READ PARISH COUNCIL

Planning Application No: 3/2013/0548

Proposal: Proposed two-storey and single storey extensions. Re-submission of 3/2013/0175P

Location: Glenlivet, Straits Lane, Read BB12 7PE

## PROPOSED PARKING PLAN.

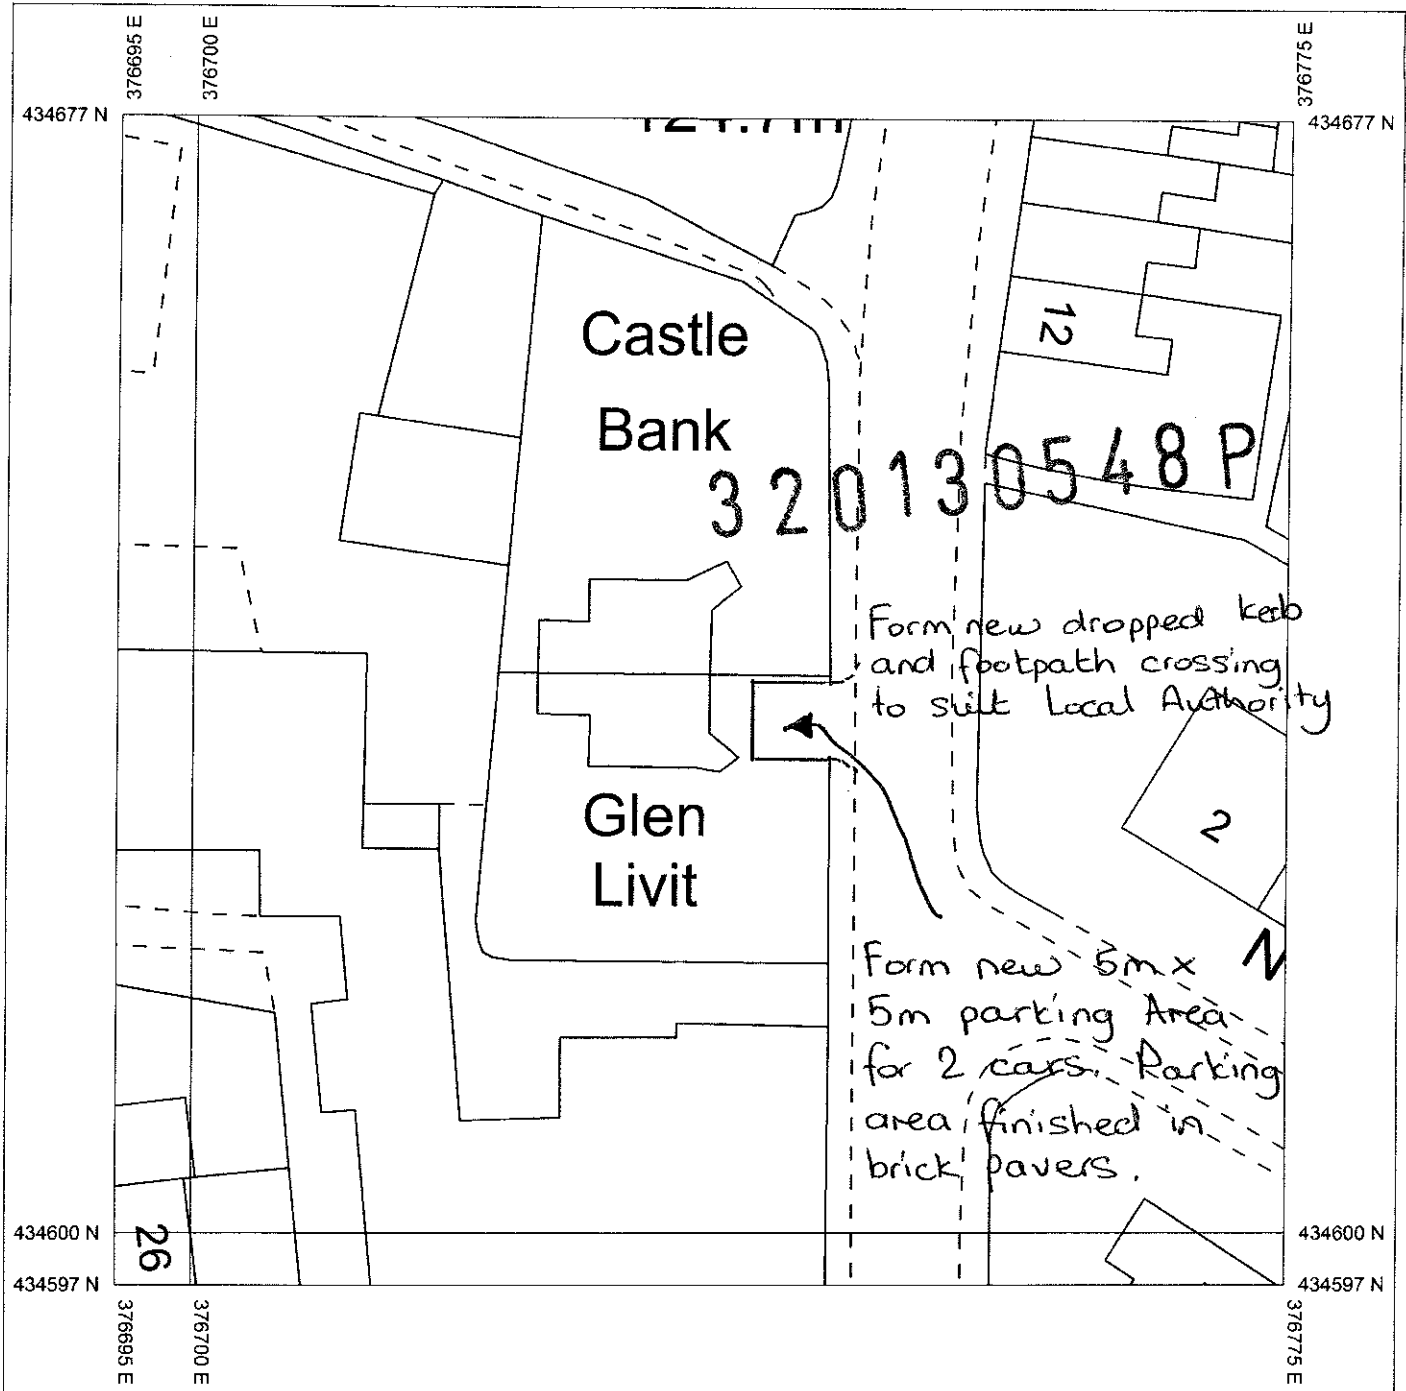
The Parish Council have no objections to this application but would ask that consideration be given to re-siting the drive, making access across the zig-zig school no parking area, would allow a greater length of road where parking is possible.
